Submission: SSD-78996460 – 16-24 Lord Street & 21-27 Roseville Avenue, Roseville

I am writing in objection to the State Significant Development Application (SSDA) identified as SSD-78996460 for a 9-storeys residential development (the proposed development) at 16-24 Lord Street & 21-27 Roseville Avenue, Roseville (the site).

Figure 17 Potential development under the Housing SEPP within the TOD area

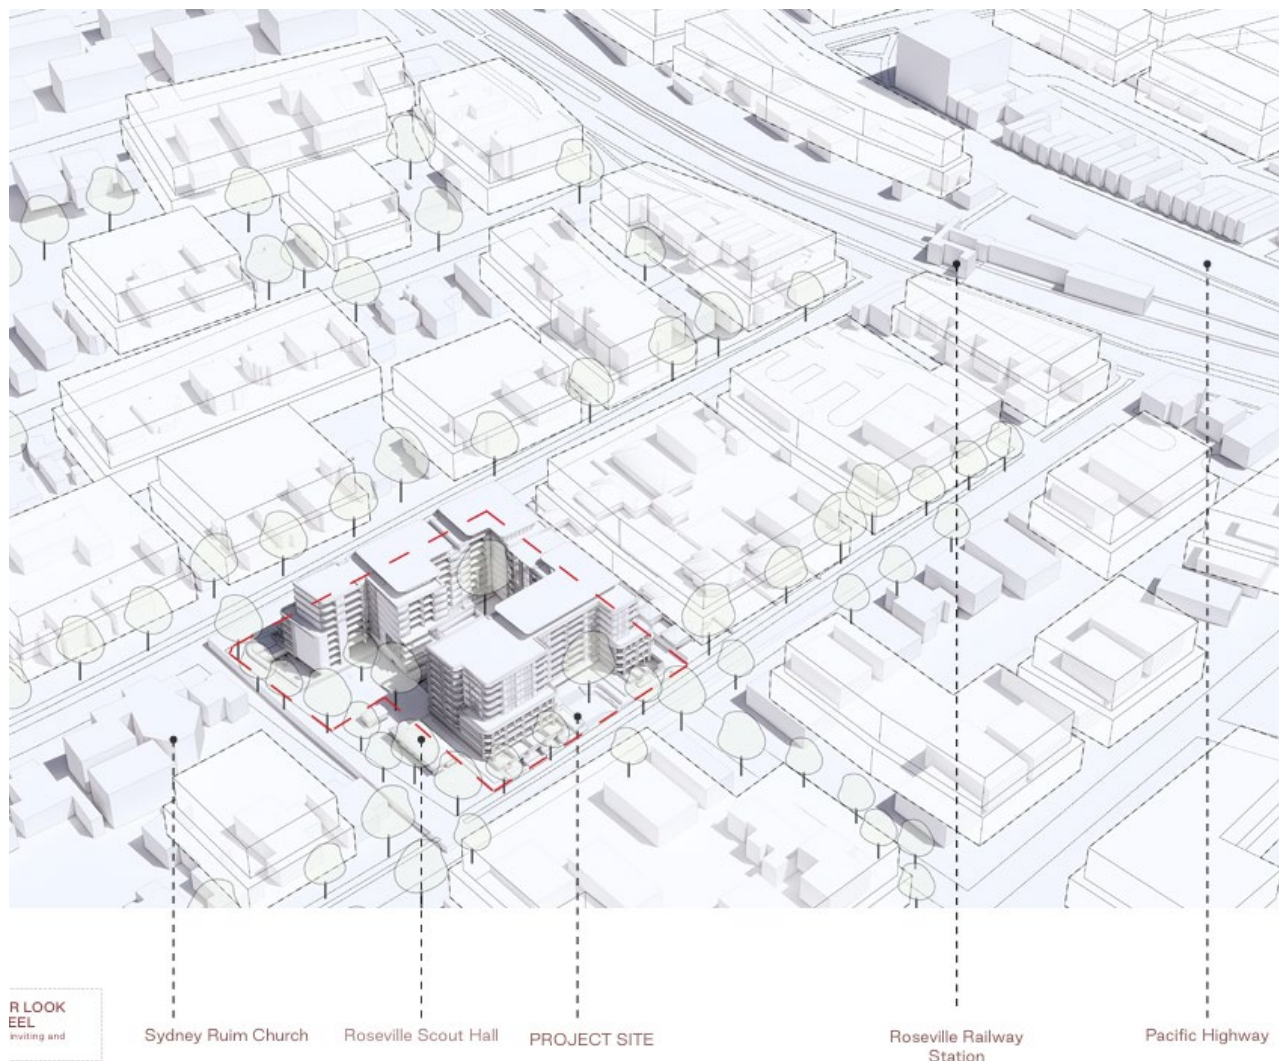
- The Environmental Impact Statement (EIS) and supporting documentation consider the surrounding context as being consistent with the State TOD controls under the Housing SEPP which will disapply after 13 June 2025. Diagrams such as Figure 17 of the EIS are deliberately fictitious portraying the proposed development sitting within a suitable urban density, and downplay the existing surrounding heritage buildings. It displays an outright dismissal of the impact of bulk and scale to adjacent properties, and will clearly overwhelm the streetscape and surrounding local heritage items.

Following DPHI's decision, the depiction of the proposed development in the context of the State TOD controls is now misleading and not an accurate representation of the surrounding context. In their assessment, DPHI must consider the existing surrounding context which is consistent with Council's preferred scenario which will apply after 13 June 2025.
